ADVICE RESPONSE: Woodlawn Mine Mod 3 - Infrastructure and Final Land Use Updates

Stage: Modification Report

Development Application: MP07_0143-Mod-3

I refer to the Woodlawn Mod 3 – Infrastructure and Final Land Use Updates (MP07_0143-Mod-3) report (Mod 3 Report) submitted to the Resources Regulator on 16 April 2026. Based on the review of the Mod 3 Report, the Regulator has identified a number of matters as described below.

APPENDIX 4 REHABILITATION PLAN

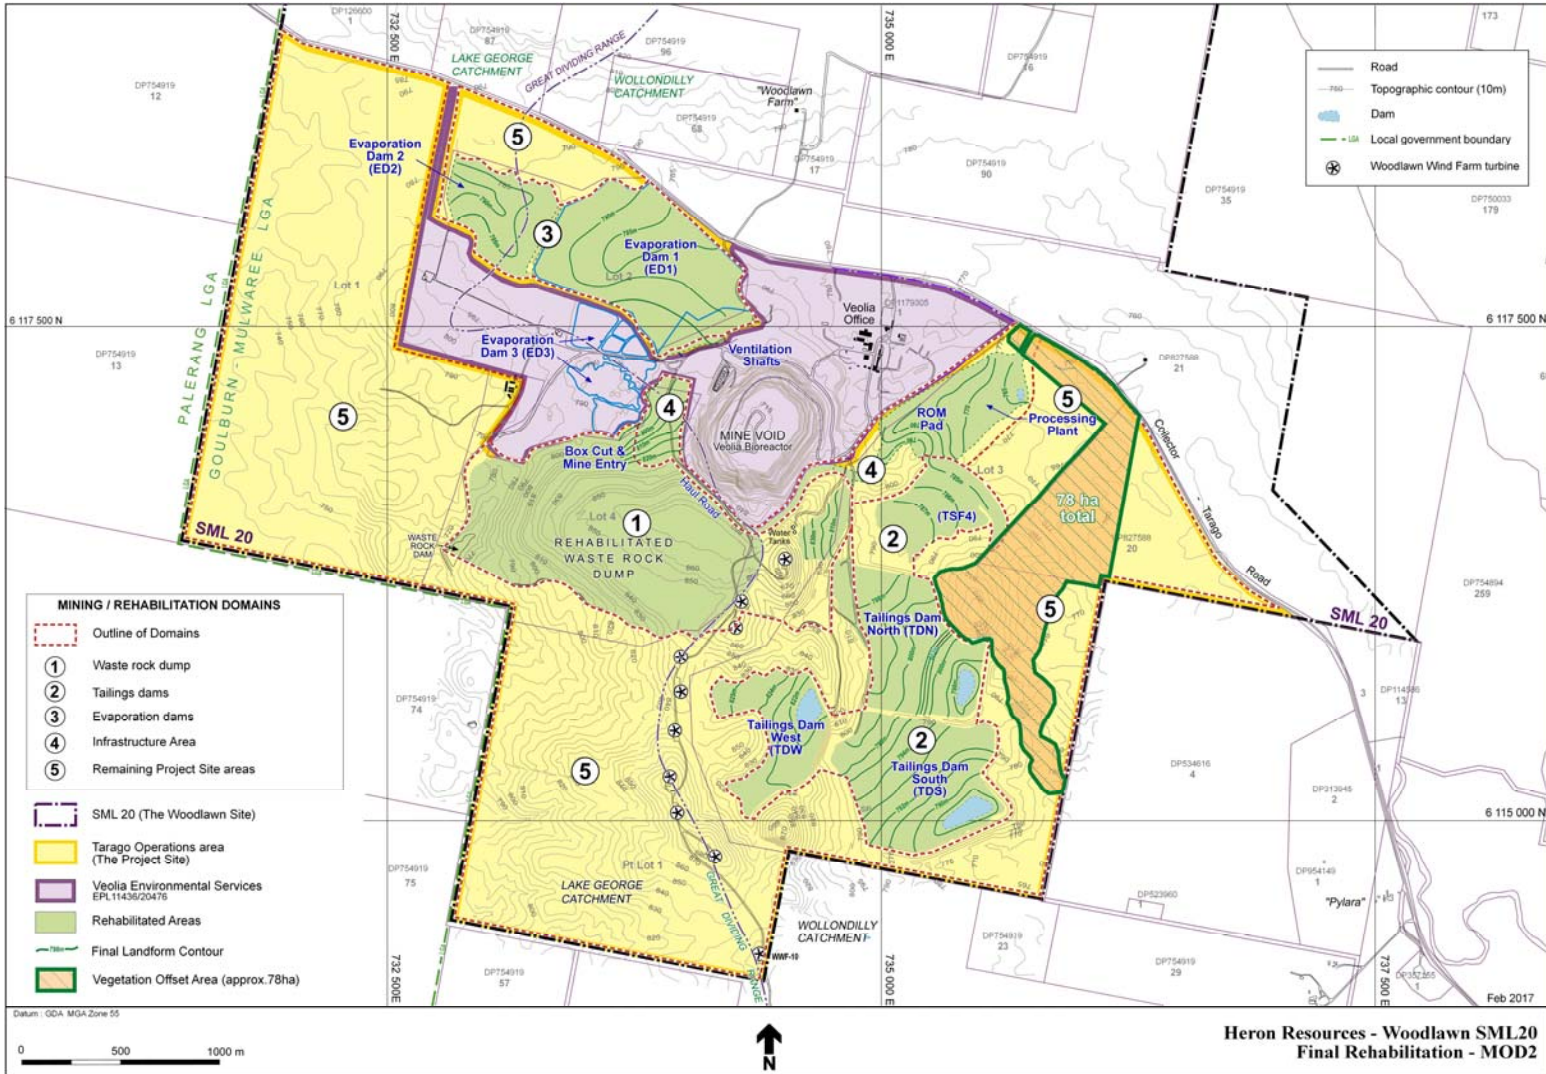
The proponent is seeking an amendment to the rehabilitation objectives for the "Mine site (as a whole)" in Schedule 3, Condition 6 of PA 07_0143 to remove reference to the vegetation community as outlined in Table 3.3 and replacing it with a reference that rehabilitation will be in accordance with the final land use domains in Appendix 4 of the development consent (Figure 3.3 of the MOD 3

- Figure 3.3 depicts the final land use as "Rehabilitated area" over the entire mine site, which is non-specific and doesn't reflect potential limitations with mining domains across the site (e.g. tailings dams, waste rock dump) to support the proponents intended heavy industrial land use; and
- Whilst the land is zoned Heavy Industrial, there has been no approved post-mining land use granted beyond cessation of mining to provide certainty in terms of the standard/type of rehabilitation to be achieved.

Therefore, further information is required in regards to specific final land uses to be achieved across the mine site.
